Rezoning Transportation Analysis

Petition Number: 2024-006

From: Jake Carpenter, PE

Date	Description
2-21-24	First Review (NK)
4-24-24	Second Review (NK)

SHEET NUMBER  
**RZ-1**

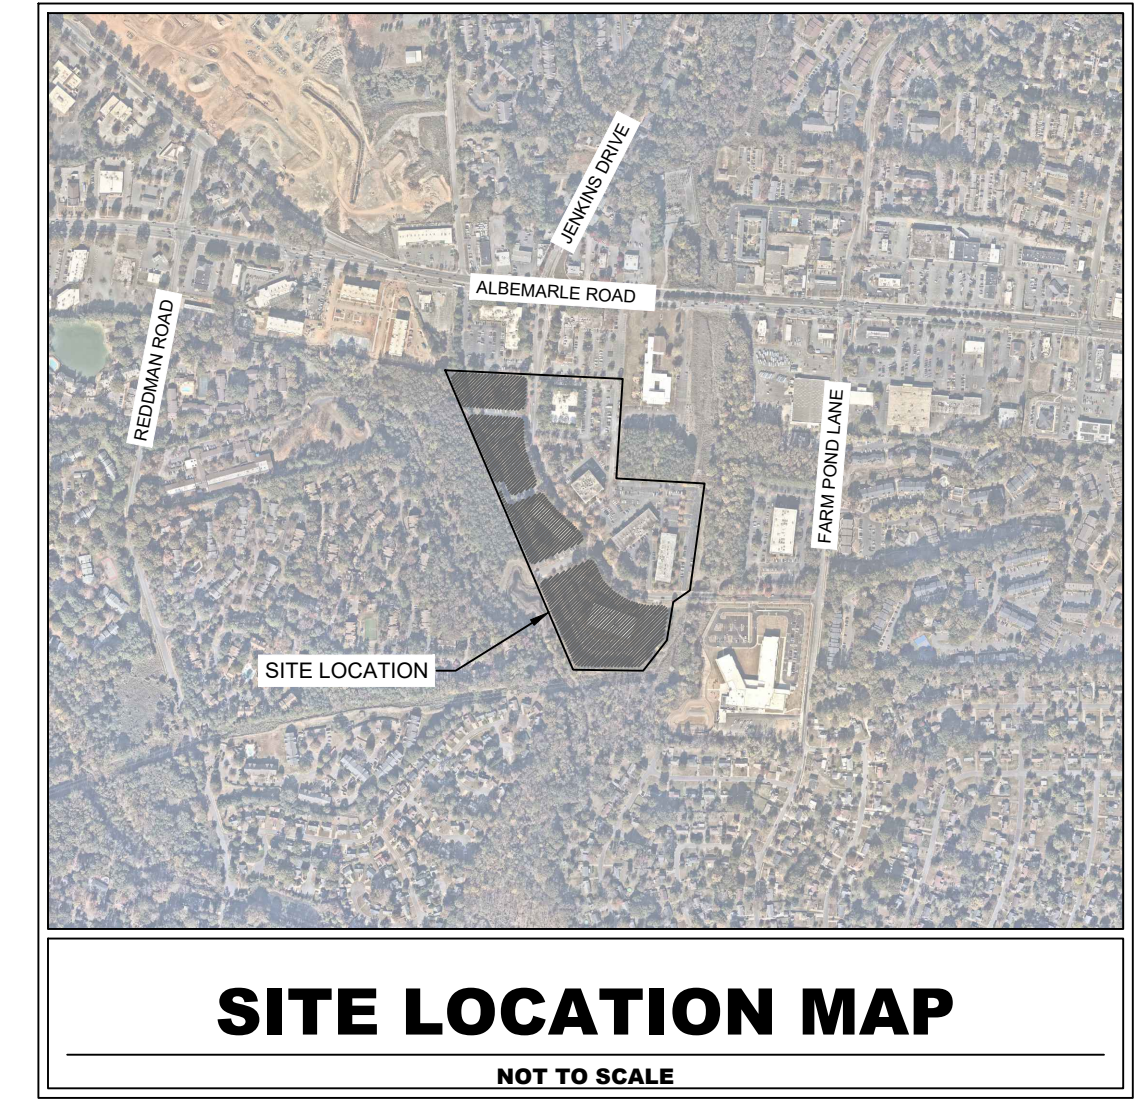
- 2. Comprehensive Transportation Review (CTR):** Confirm that land uses on the parcels included in the rezoning have been active within the last year. This will help determine if any CTR requirements are triggered.

04-24-24 Outstanding Comment: Confirmation is still needed on whether existing uses are active. Reach out to Drew Ritter at andrew.ritter@charlottenc.gov for additional requirements.

- ~~6. Revise site plan and conditional note(s) to show access points for each parcel.~~
7. CDOT **request** site plan and conditional note(s) to commit to installing new cross access to adjacent parcel if Hollins Drive is abandoned.

9. **New Comment 4.24.24:** Include cross section for Executive Center Drive which should follow CLDSM detail U-07B shown below:

10. **New Comment 4.24.24:** CDOT requests that the petitioner constructed raised buffered bike lanes along Executive Center Drive along the project frontage.
